CITY OF ALBUQUERQUE

March 28, 2019

RE: **Lexus Parking Lot Expansion**
4811 Pan-American NE
Grading Plan Stamp Date: 3/15/19
Hydrology File: F17D102

GRADING PLAN  
LEXUS LOT EXPANSION

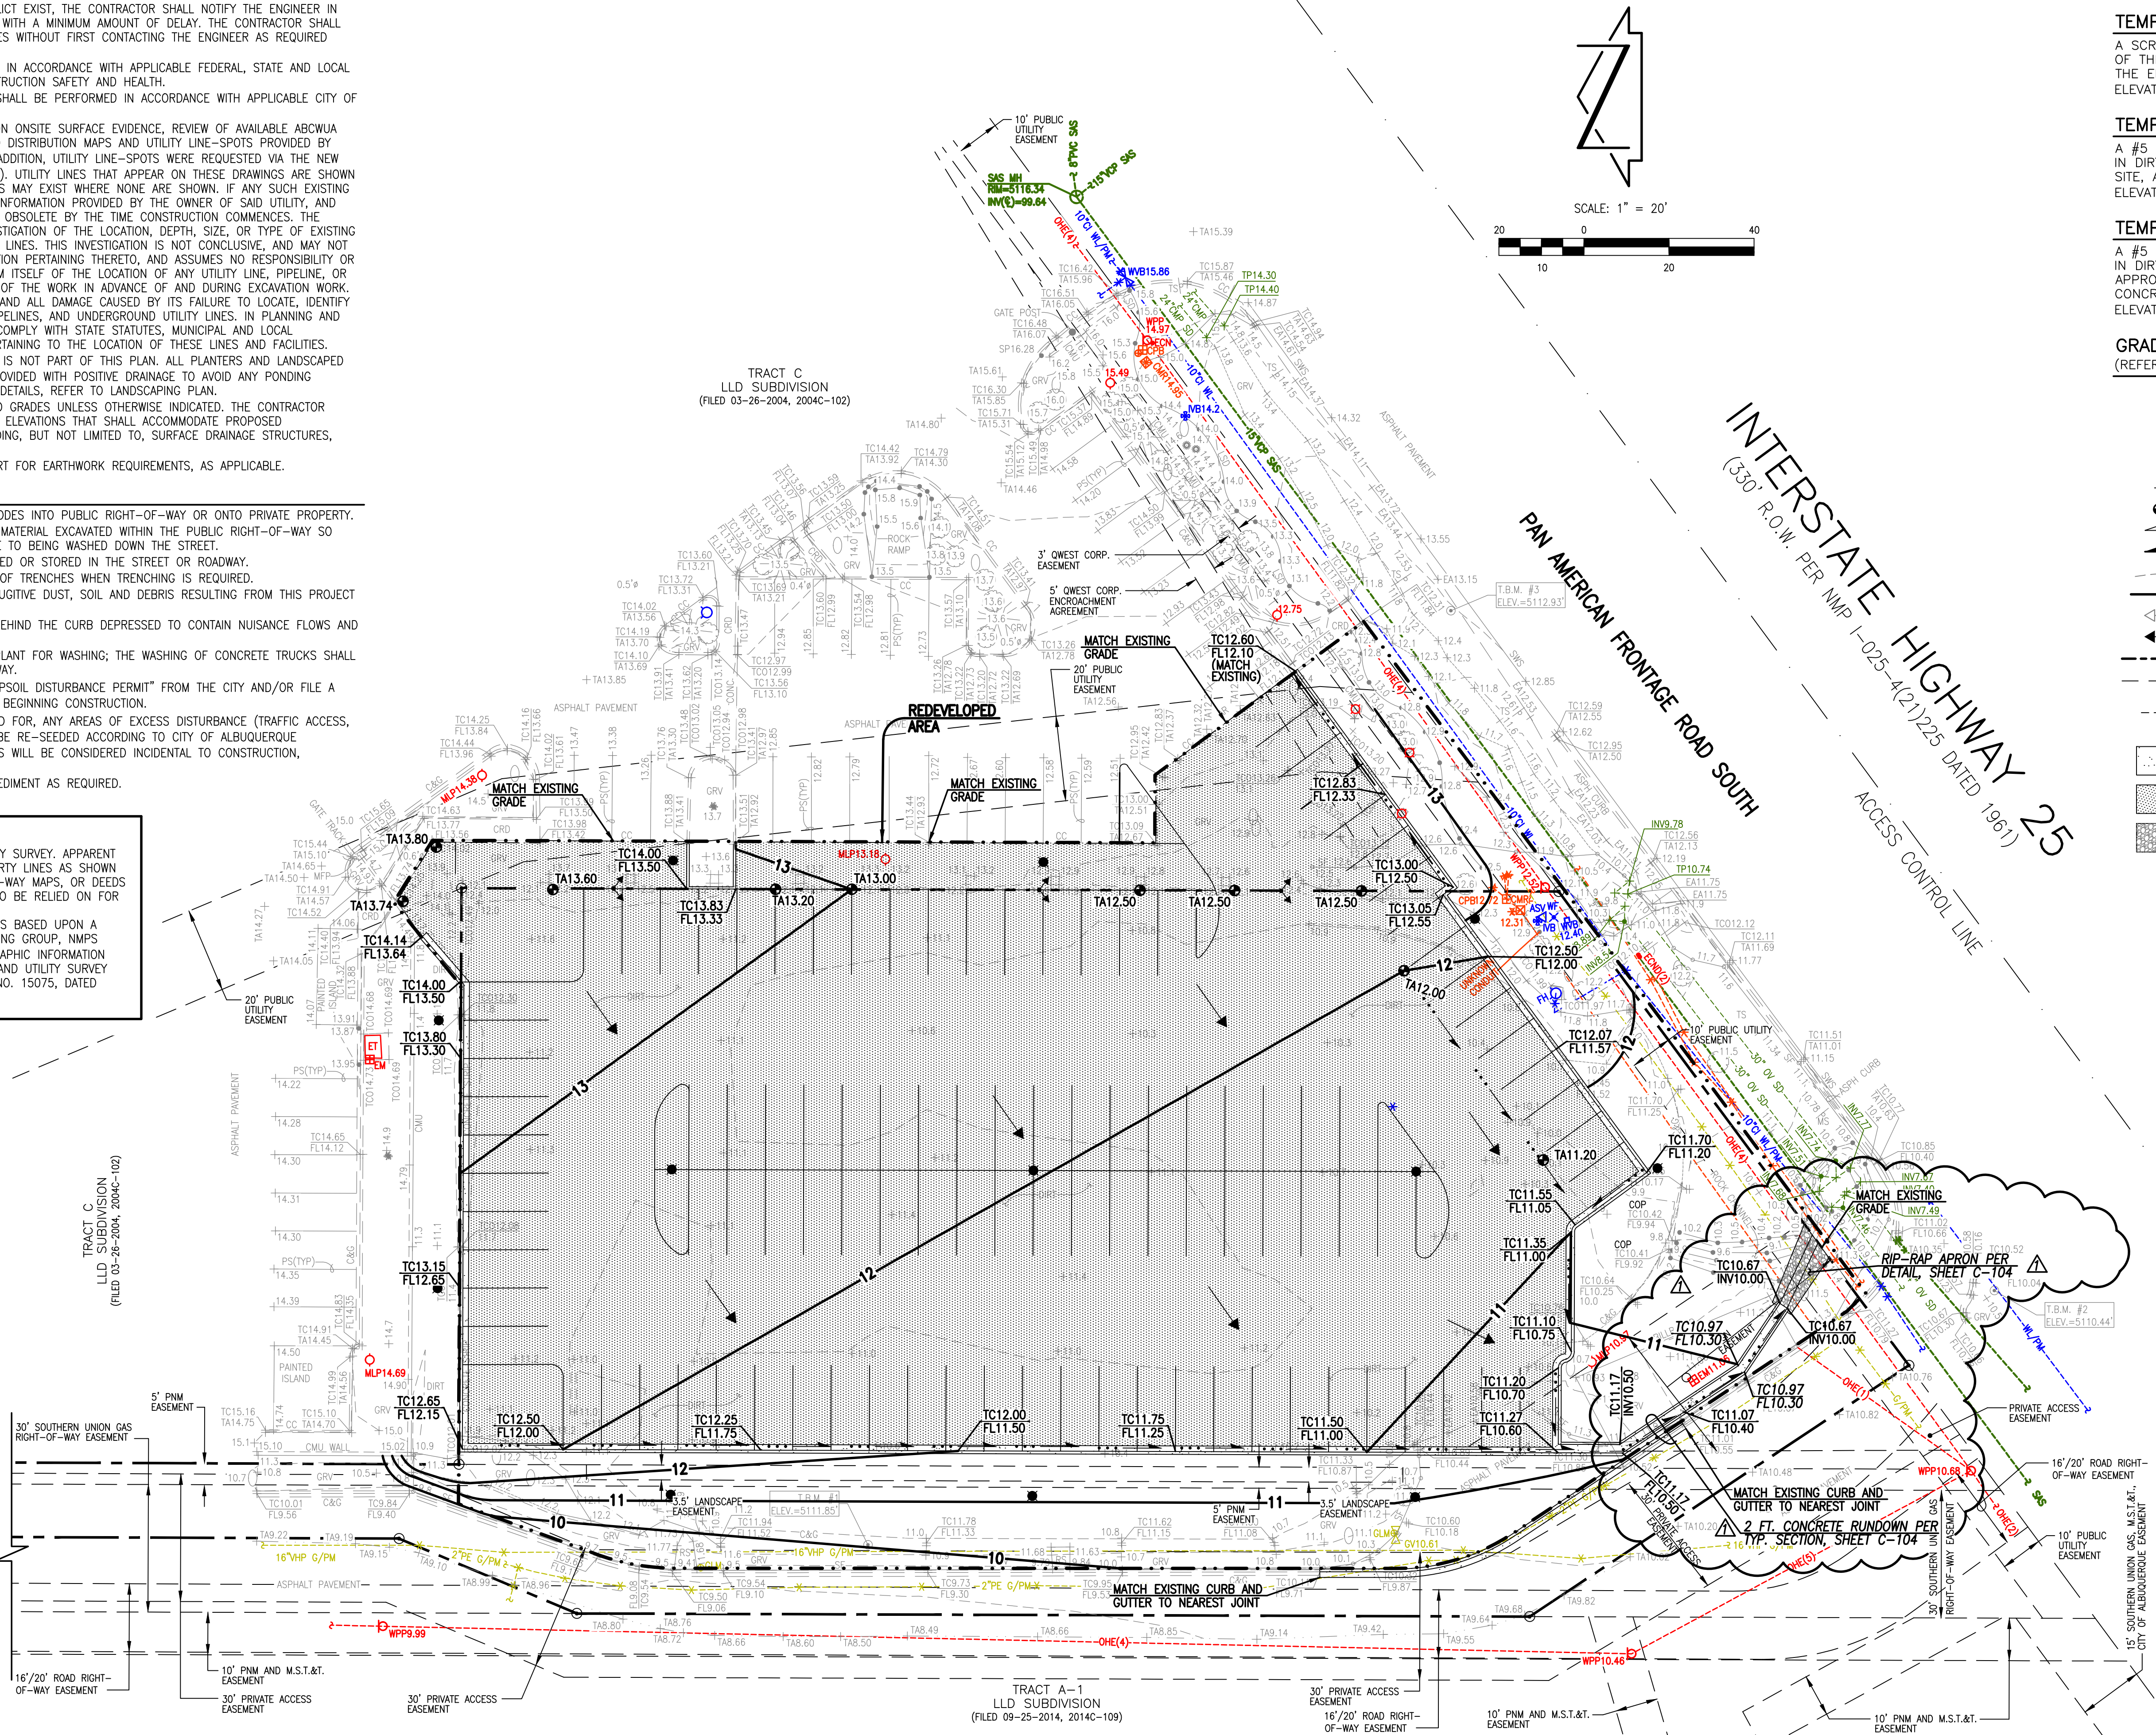
4. Hydraulic calculations are missing for the concrete rundown channel, no channel width is called out on plan view, and the plan view doesn't reference the channel section on C-104. Capacity (flow depth) also needs to be checked along the south curblin to ensure the 6" curb is high enough.

**1**  
RIP-RAP APRON DETAIL  
SCALE: 1" = 4'-0"

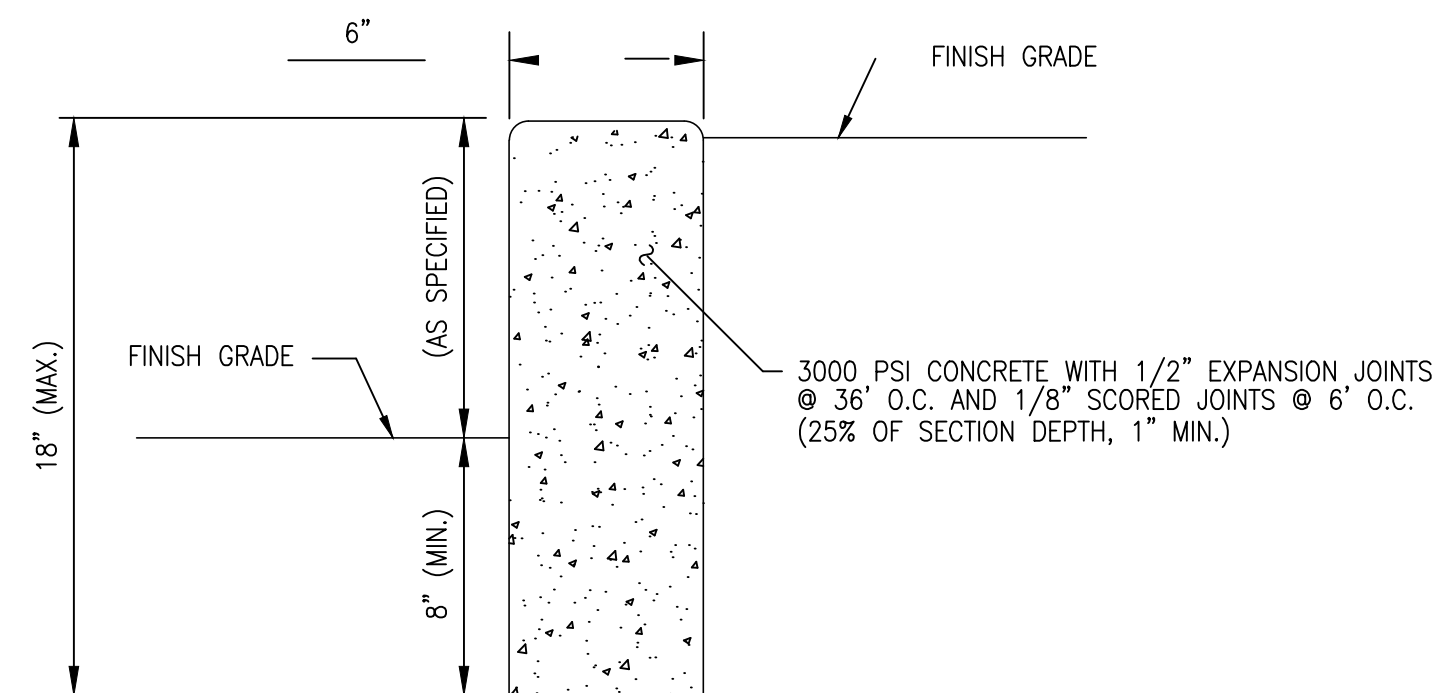
5. The rip-rap pad should be formed into a channel with its dimensions called out. You probably want a turn-down or cut-off wall where the concrete channel terminates, in case of scour there.
